Our ref: DOC22/994450  
Your Ref: SSD-41306367

**Subject: EHG Comments on the Environmental Impact Statement for New Primary School at Gregory Hills (SSD-41306367)**

### Attachment 1: EHG Comments and recommendations – EIS for New primary School at Gregory Hills (SSD-41306367)

Figure 1, tree retention value site plan

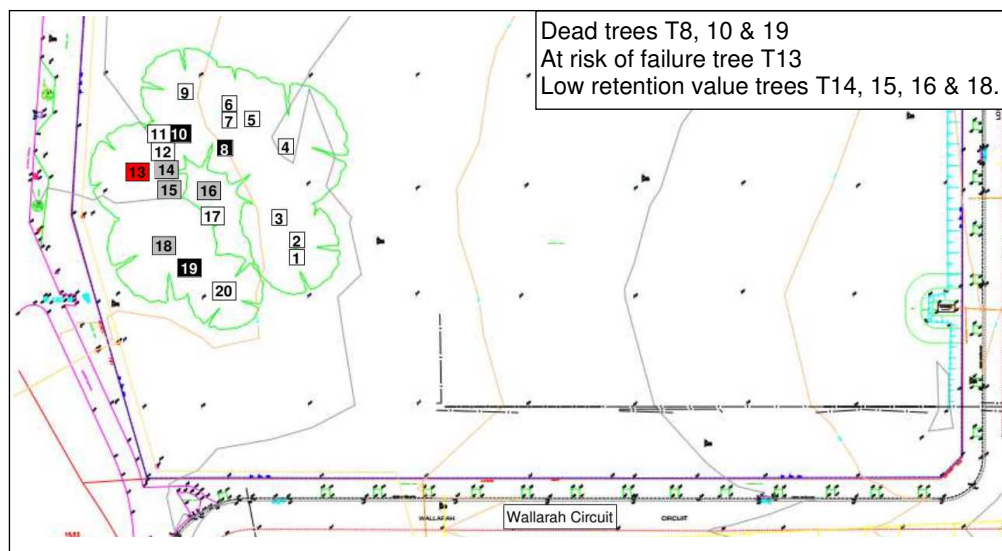
However, EHG notes that not all the trees proposed for removal meet the exemptions under Chapter 2 Clause 2.7 of the Biodiversity and Conservation SEPP. In this regard the AIA is proposing the removal of Trees 14, 15, 16 and 18 as these trees are considered to have a low retention value. In addition, no evidence has been submitted to demonstrate that the Camden Council is satisfied that Trees 8, 9 and 10 are dead and dying and not required as habitat of native animals and that Tree 13 is a risk to human life or property. EHG also notes that the trees are being removed to facilitate the use of the site as a school under the SSD. EHG therefore recommends that the requirements of RBM 19 are complied with.

Figure 2, showing proposed development footprint & tree removal plan

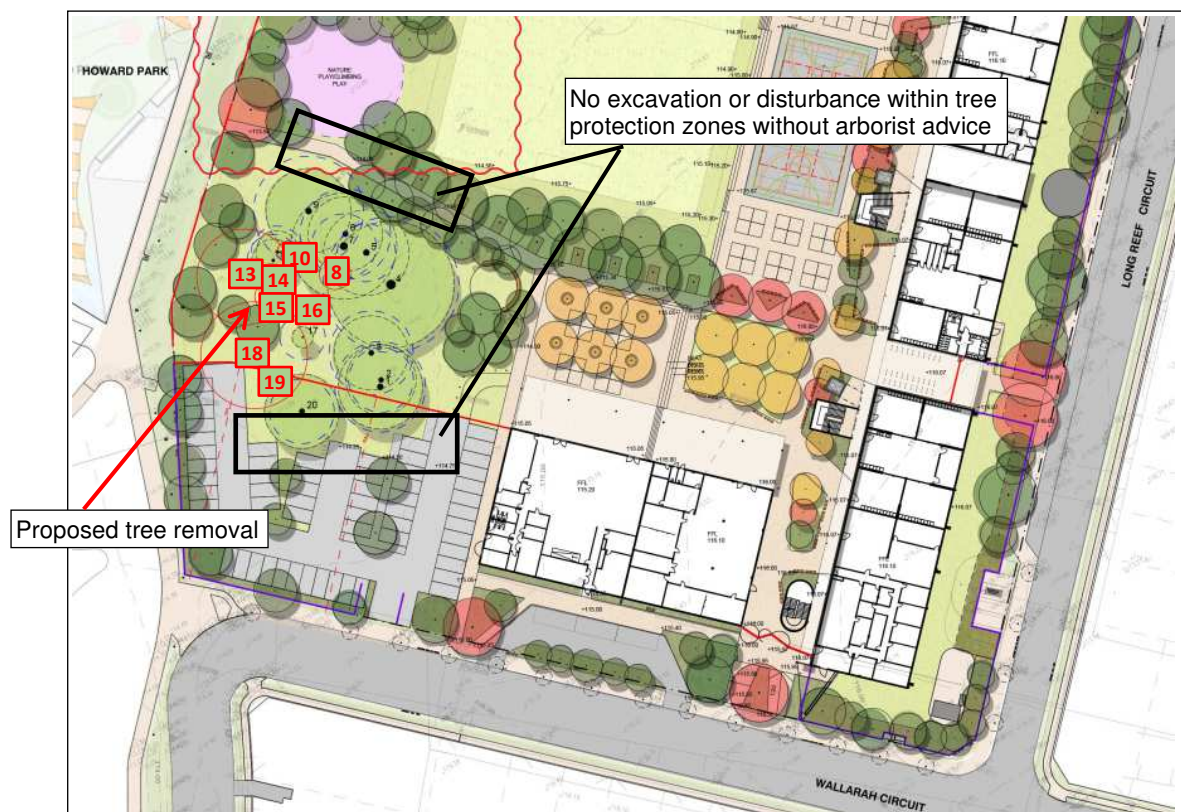
- Table 2 Direct Biodiversity Impacts resulting from the proposed development does not address impacts associated with the proposed removal of trees 8, 10, 13, 14, 15, 16, 18 and 19.

- Page 13 of the AIA advises that to ensure tree impacts are minimised ideally development should not encroach within >10% of the TPZs. Further to this, Section 2.1.3 of the AIA includes recommendations to reduce impacts to the TPZs of Trees 1, 2, and 20. EHG supports the AIA recommendation that the carpark should be reconfigured to reduce impacts to the tree protection zones of Trees 1, 2 and 20.
